**EL PASO COUNTY PLANNING AND
 COMMUNITY DEVELOPMENT
 DEPARTMENT**

STORMWATER MANAGEMENT PLAN CHECKLIST

Revised: July 2019

Vehicle Tracking Control (VTC) SM-4

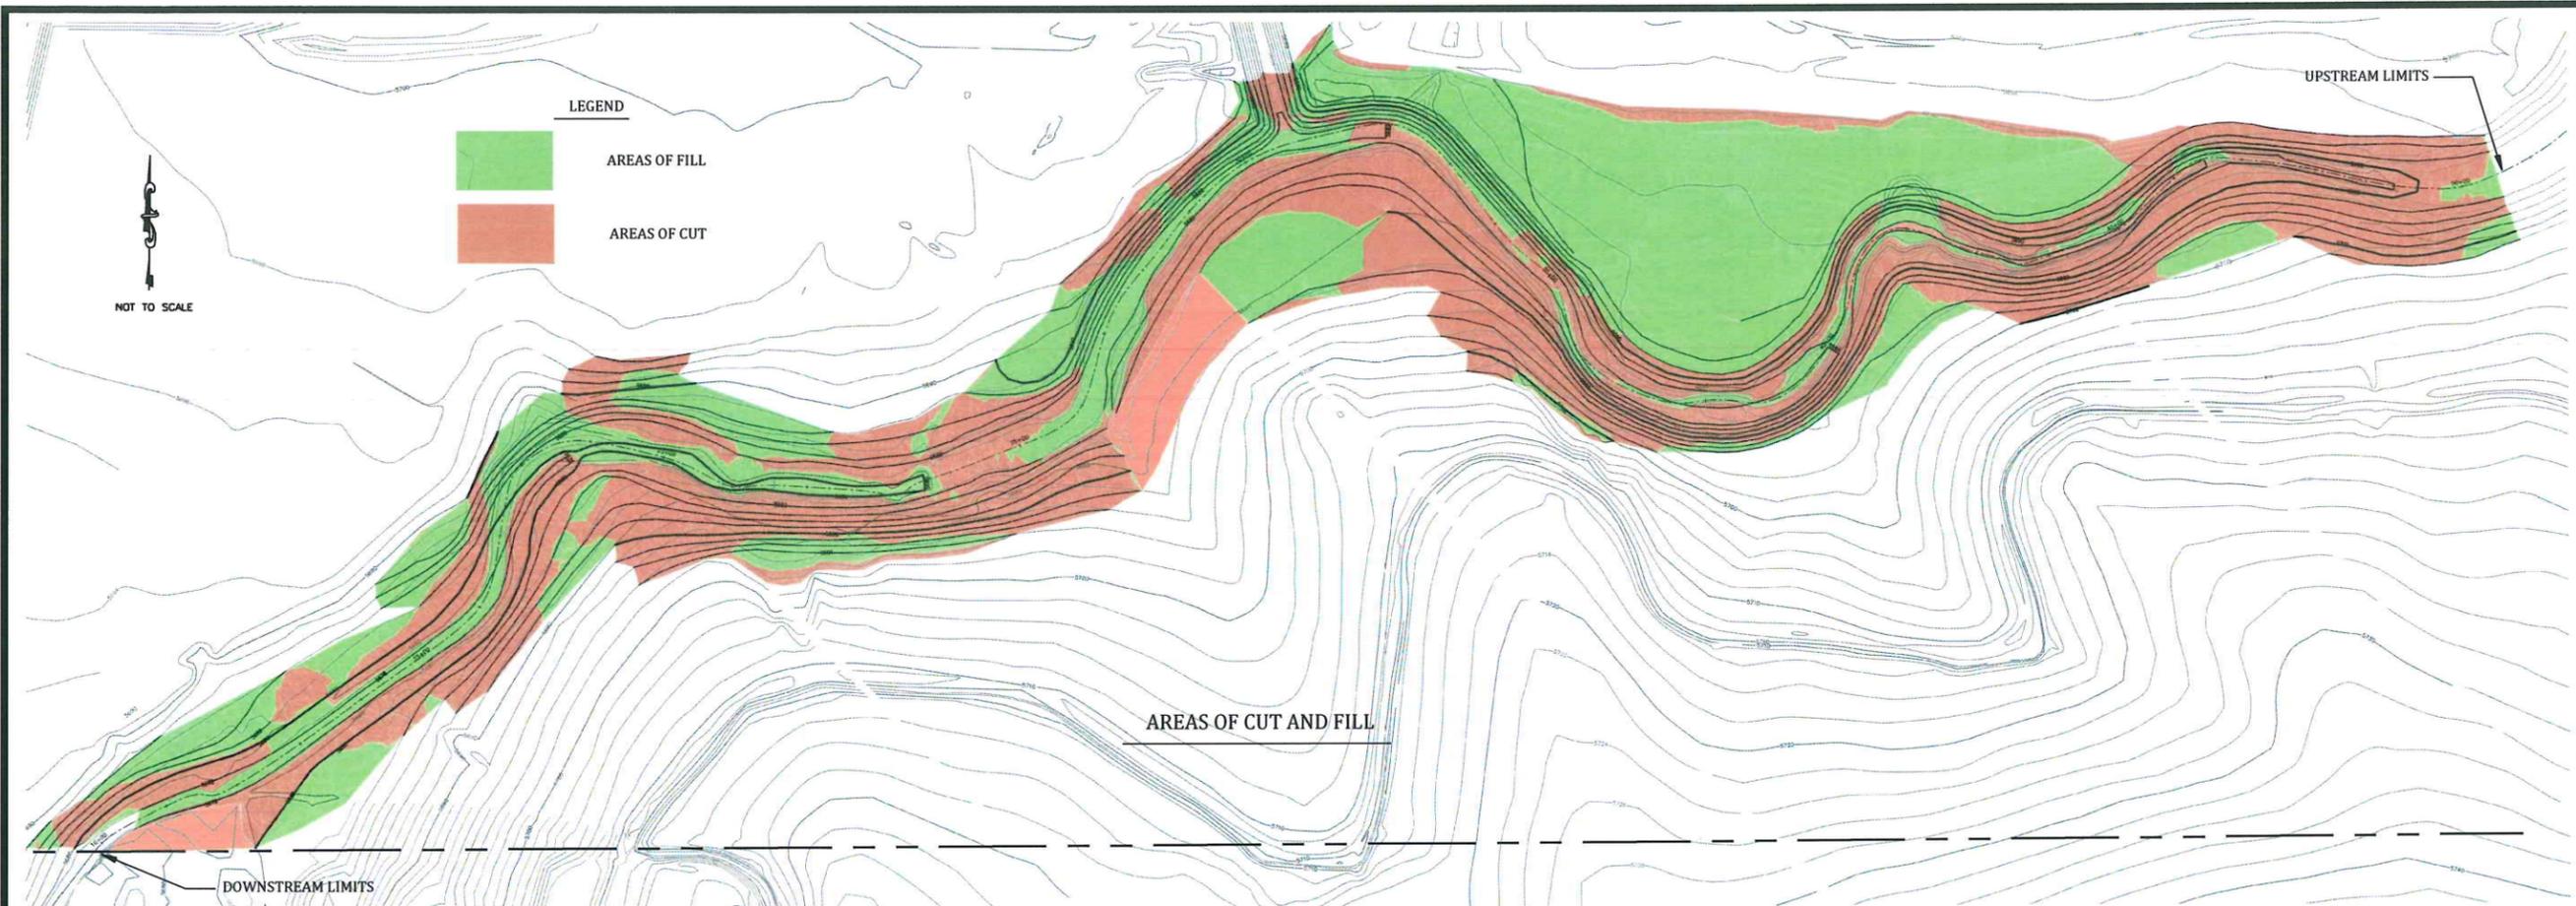
20	Technical drawing details for all control measure installation and maintenance; custom or other jurisdiction's details used must meet or exceed EPC standards Update VTC Detail	X	X
21	Procedure describing how the SWMP is to be revised	X	✓
22	Description of Final Stabilization and Long-term Stormwater Quality (describe nonstructural and structural measures to control SW pollutants after construction operations have been completed, including detention, water quality control measure etc.)	X	✓
23	Specification that final vegetative cover density is to be 70% of pre-disturbed levels	X	✓
24	Outline of permit holder inspection procedures to install, maintain, and effectively operate control measures to manage erosion and sediment	X	✓
25	Record keeping procedures identified to include signature on inspection logs and location of SWMP records on-site	X	✓
26	If this project relies on control measures owned or operated by another entity, a documented agreement must be included in the SWMP that identifies location, installation and design specifications, and maintenance requirements and responsibility of the control measure(s).	X	✓
